SEAS DEADLINE 6 RESPONSE to APPLICANTS's SUBMISSIONS
SINCE DEADLINE 5, ISH3, Action Points and ExQ3
LANDSCAPE & VISUAL and CULTURAL HERITAGE

PINS Ref: EN020026
DEADLINE 6: APRIL 13, 2026

RE: SEAS Response to Applicant's Submissions since Deadline 5, ISH3, Action Points and ExQ3 – Landscape & Visual and Cultural Heritage

EN020026 SEA LINK DCO – DL6: RESPONSE BY NICHOLAS BRIDGES

Figure 1. EN010077-001489-6.2.29.7 EAIN ES Figure 29.7 Onshore Substation ZTV (with landscape character)

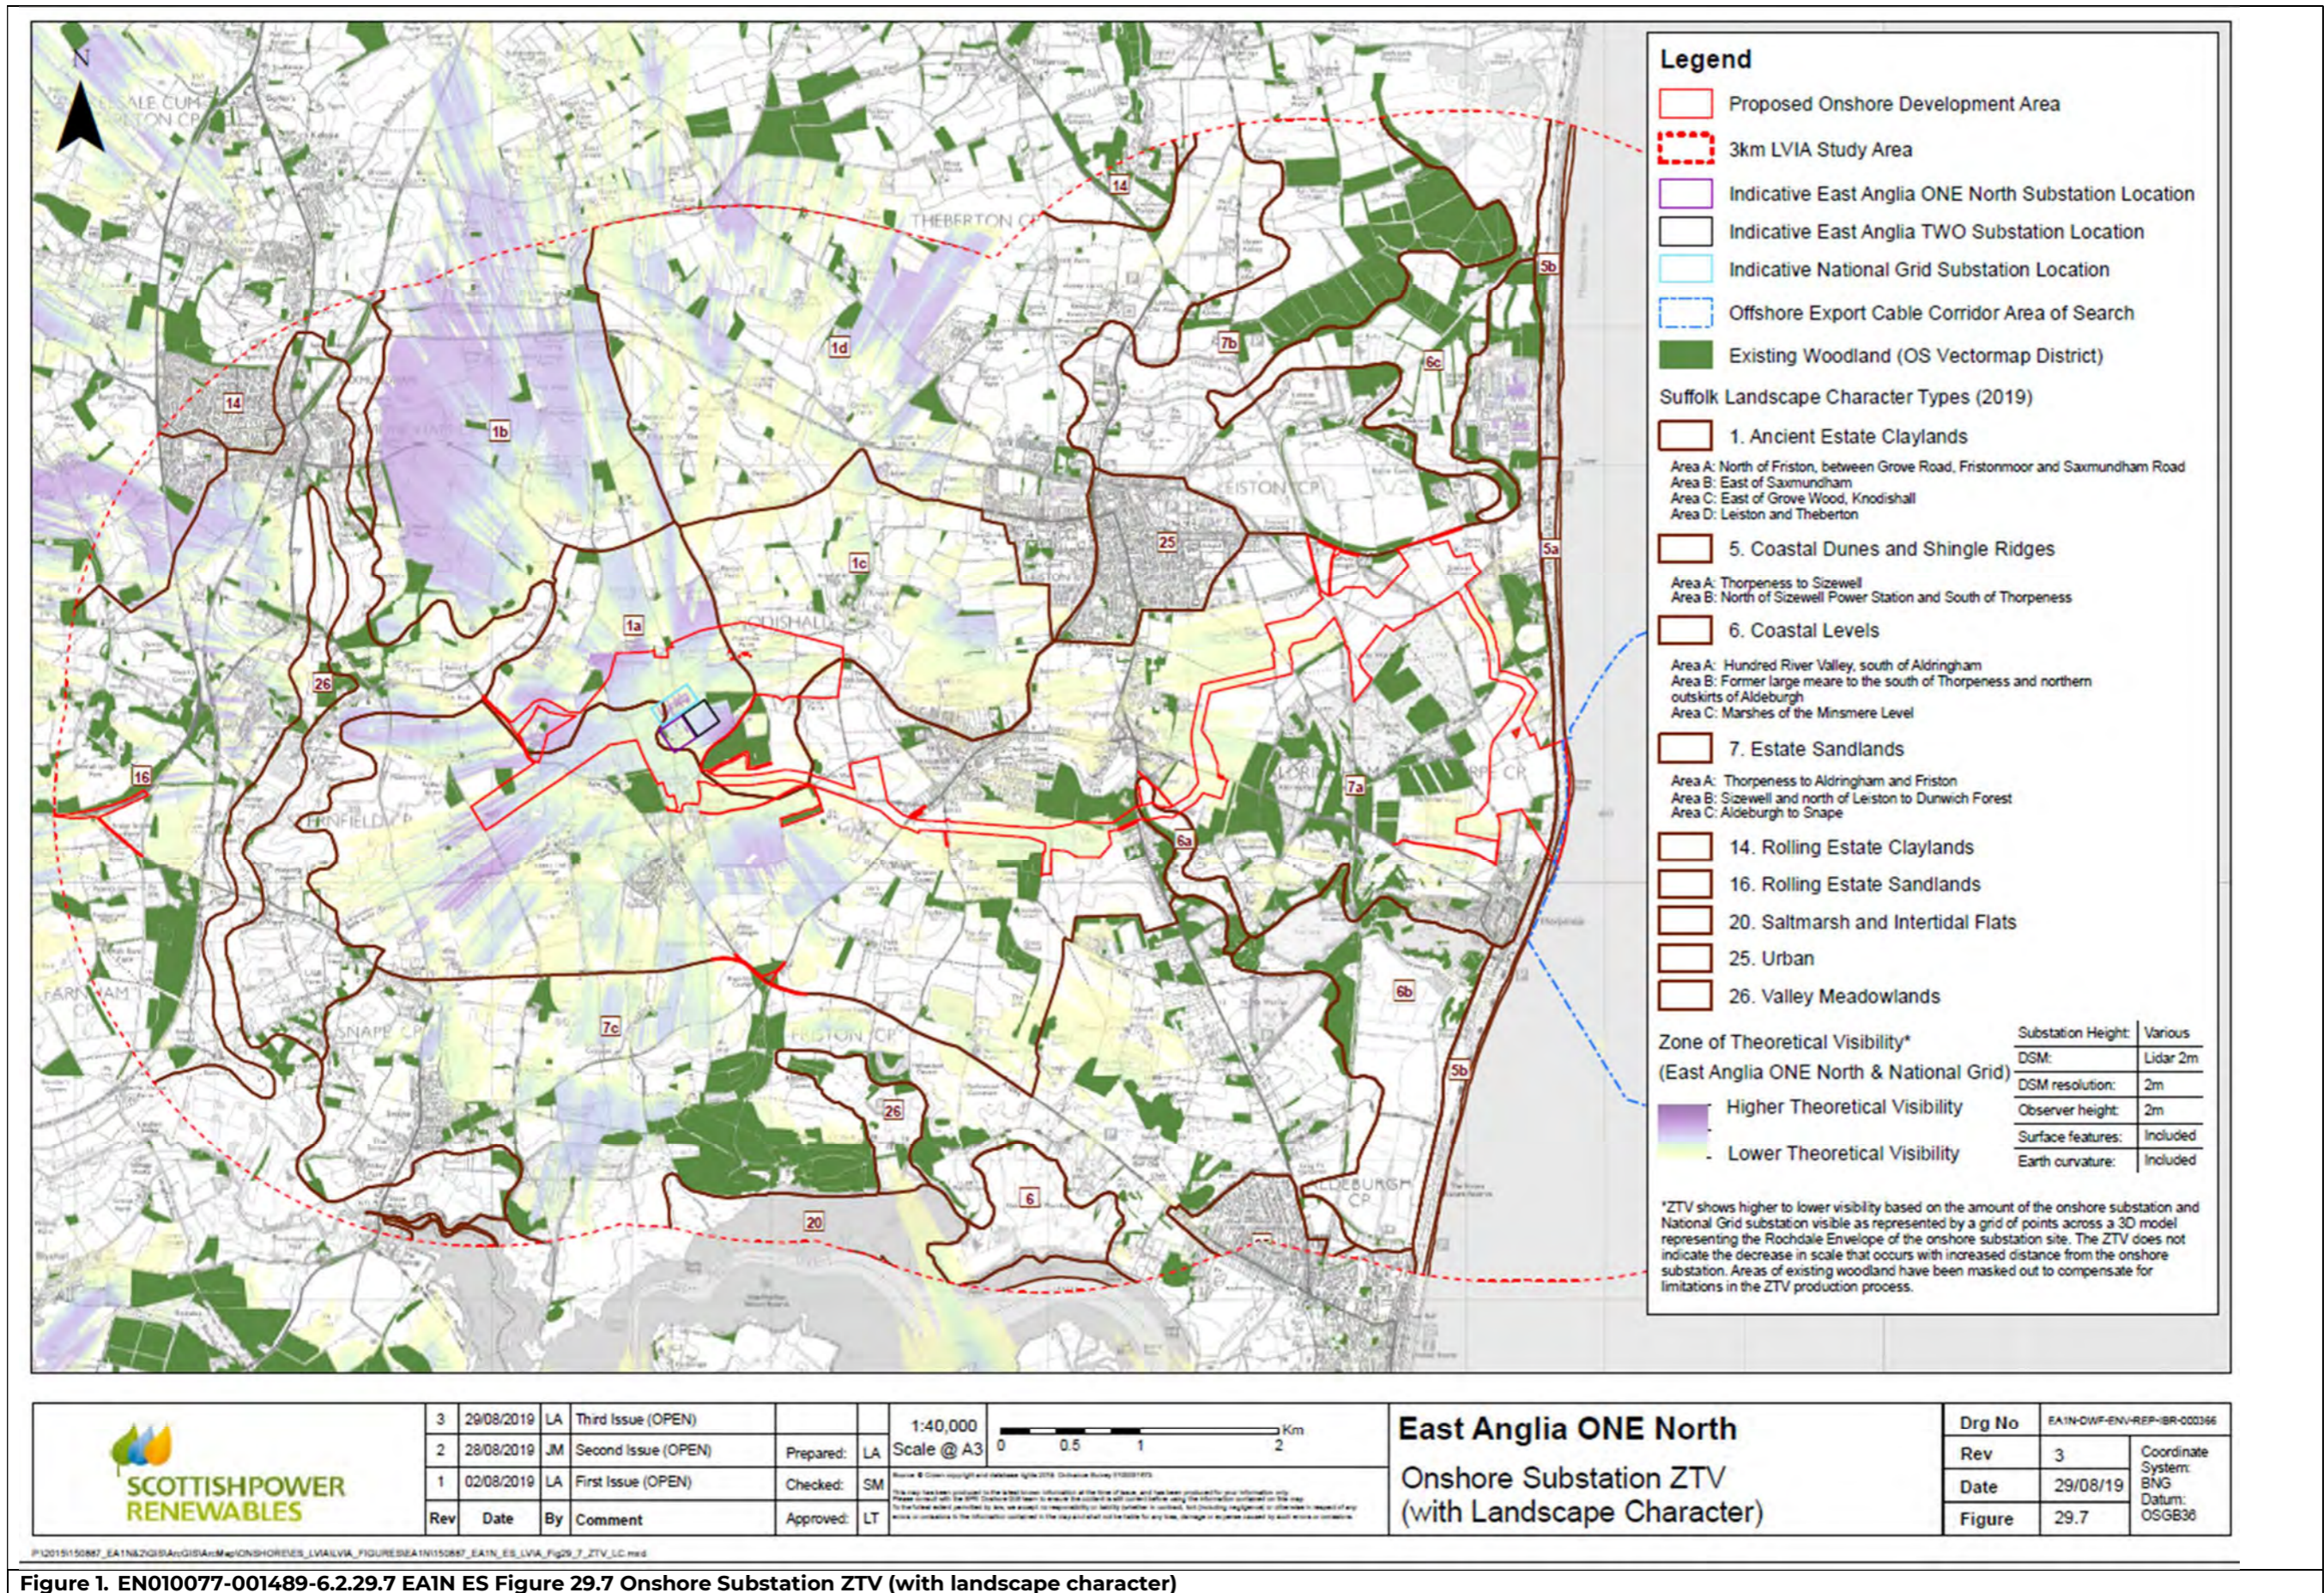
2.9. The ZTVs of the two Friston projects and Sea Link's PEIR have a similar pattern of visibility around their projects (see **Figures 1 to 11** below). Sea Link includes the National Grid substation at Friston which each of EA1N and EA2 also included. All Projects were modelled using OS contours, woodland and buildings at a generic height. Observer heights were a little higher for EA1N and EA2. The two Friston substations used the same parameter model as Sea Link.

2.17. The applicant does not seem aware of the EA1N and EA2 ZTV plans (**Figures 1, 2 and 3** below) which show that those developments would be visible. Nor the Sea Link PEIR likewise. Visibility from the top of the church tower is not relevant as the public have no access nor is it important as a private viewing point, unlike the Martello Tower for which this use was its primary function.

**Figure 6. Sea Link 2023-10 PEIR Volume 3 Part 2 Chapter 2 Figures A, page 8:**  
 REPRESENTATIVE VIEWPOINT LOCATIONS AND SCREENED ZONE OF THEORETICAL VISIBILITY - PROPOSED SAXMUNDHAM CONVERTER STATION AND SPR FRISTON SUBSTATION (OPTION 1)

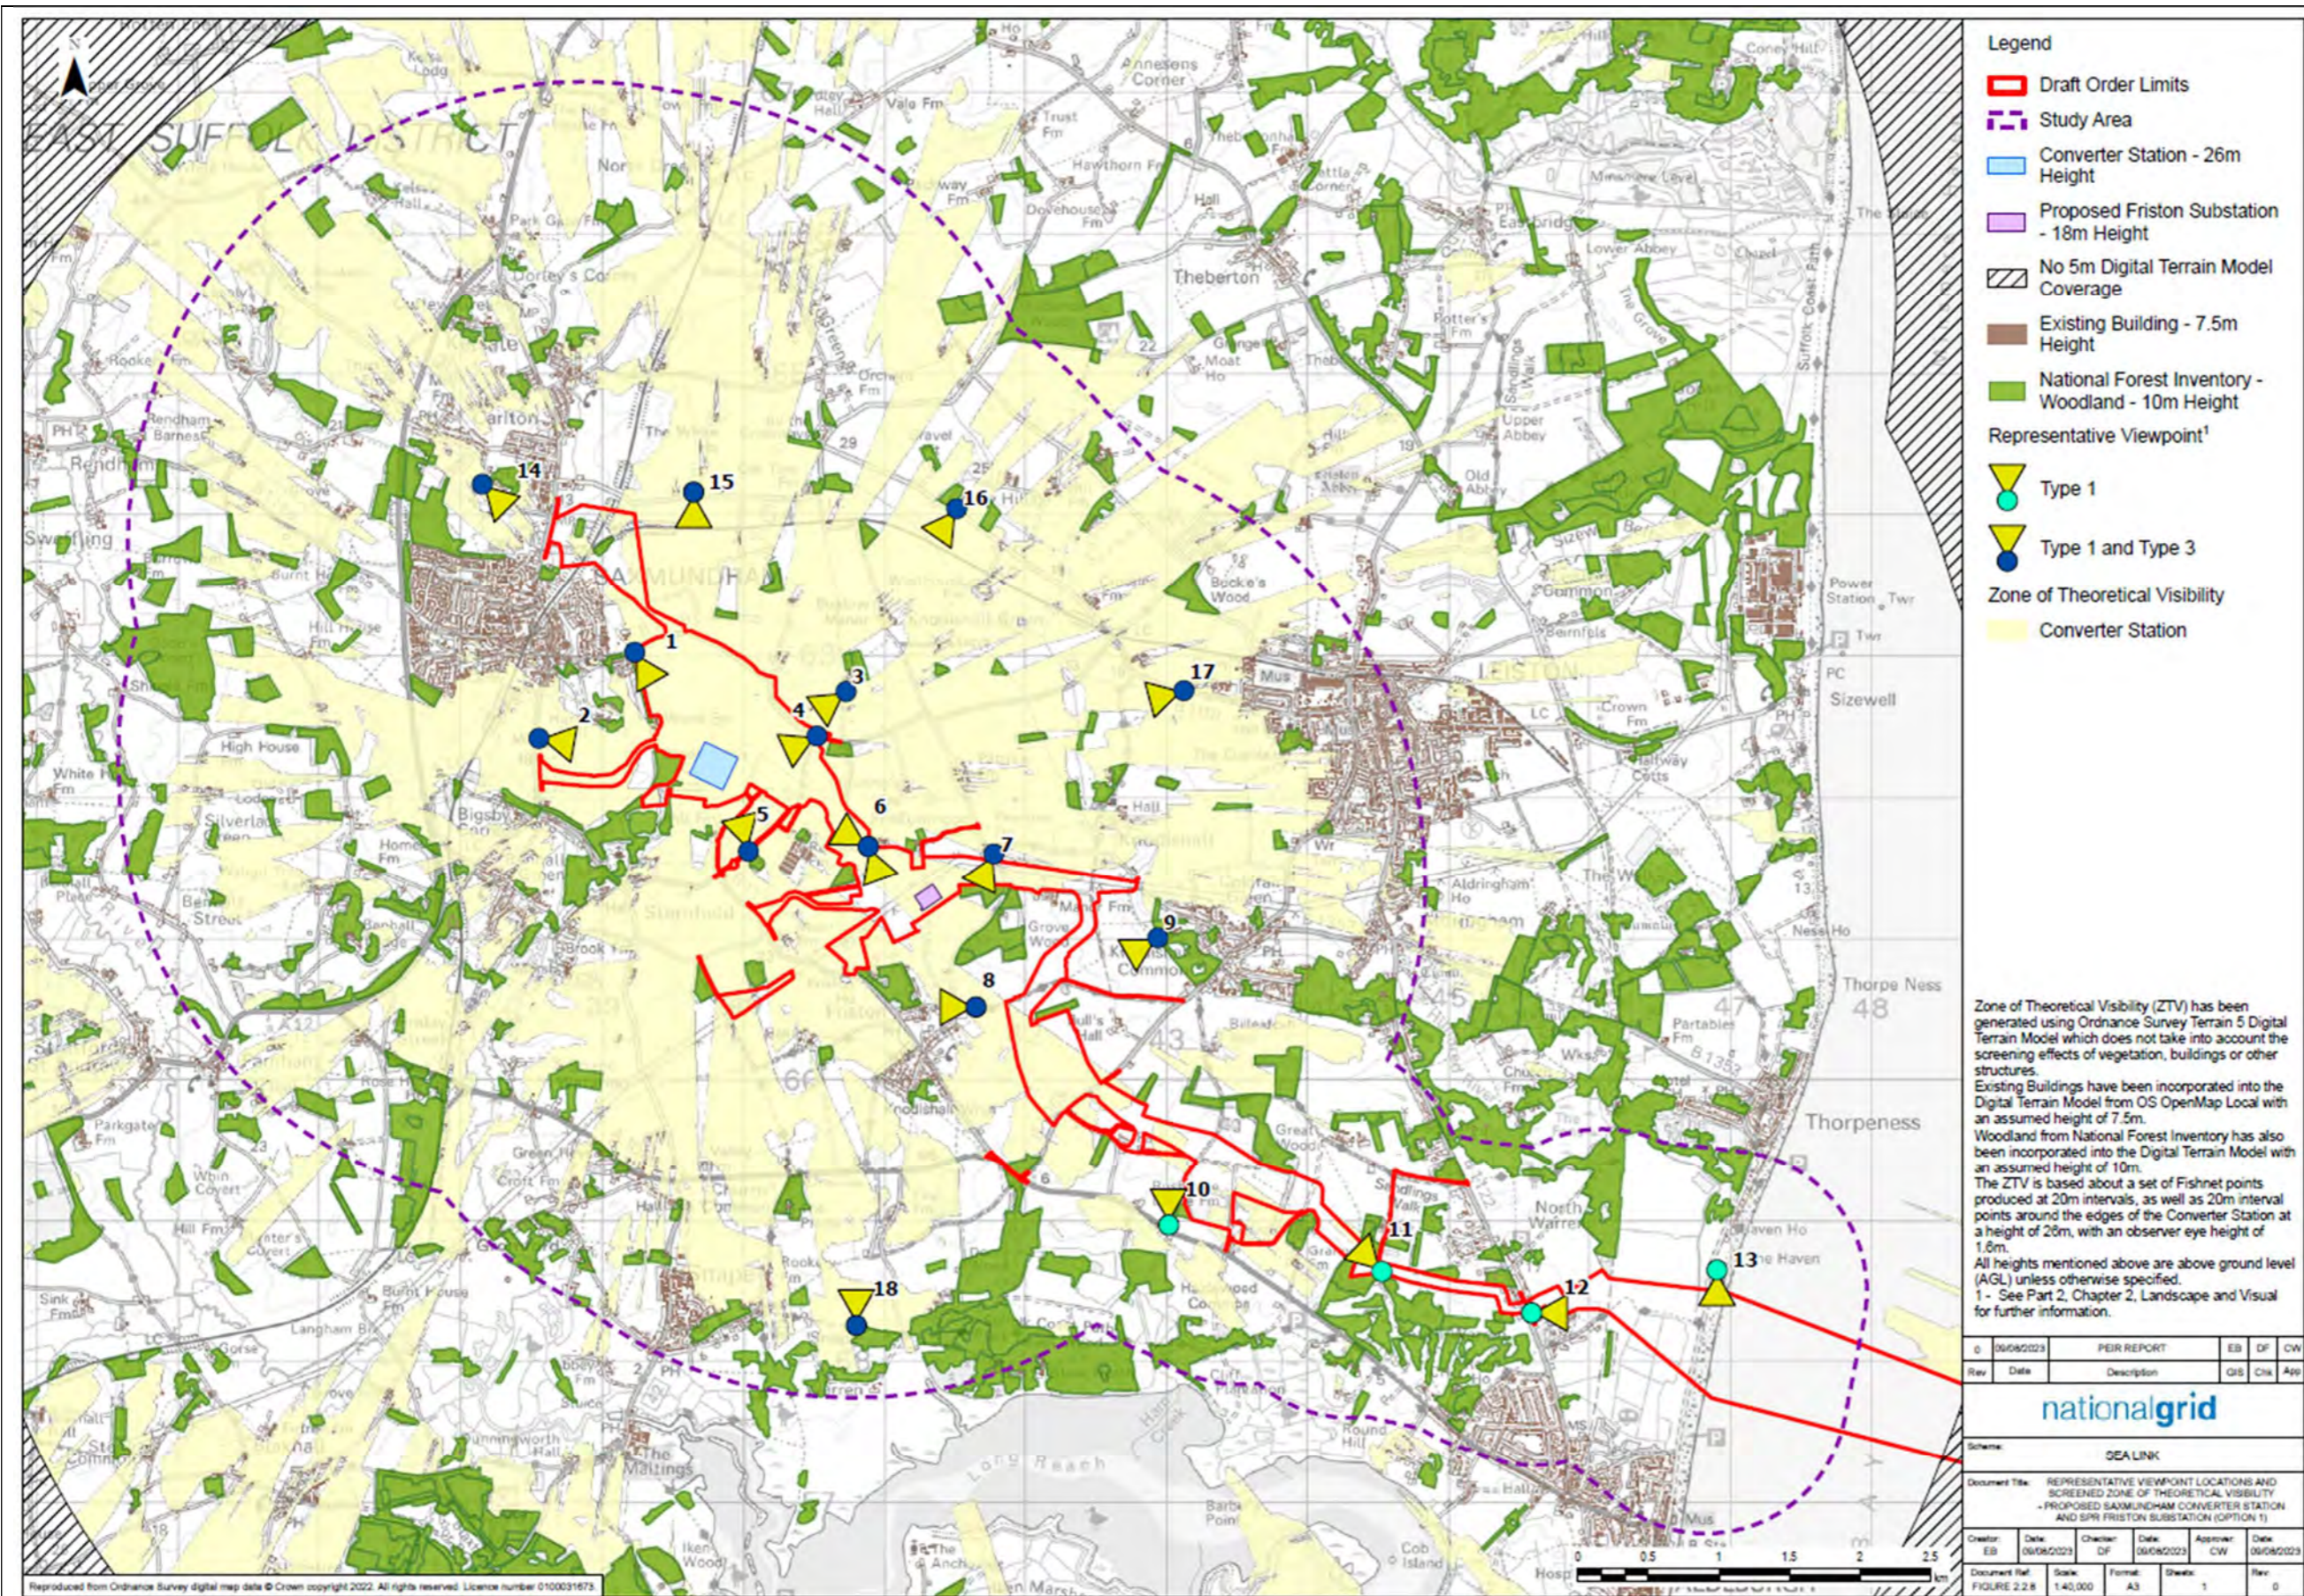
2.11. The **first question** is: why are the PEIR and DCO plans so completely different? Were the heights in the model changed? Were the shadowing criteria altered? Which is correct? If the DCO is correct, were the EA1N and EA2 ZTVs incorrect? These are simple technical points which can be explained easily.

2.12. The **second question** is: With the majority of the ZTV plans showing extensive visibility of both Friston substations (18m above ground level) and Sea Link (26m above ground level) on the south side of the Alde estuary, at high tide mark and on the 20m ridge above, why was the information on these plans not followed or commented upon?
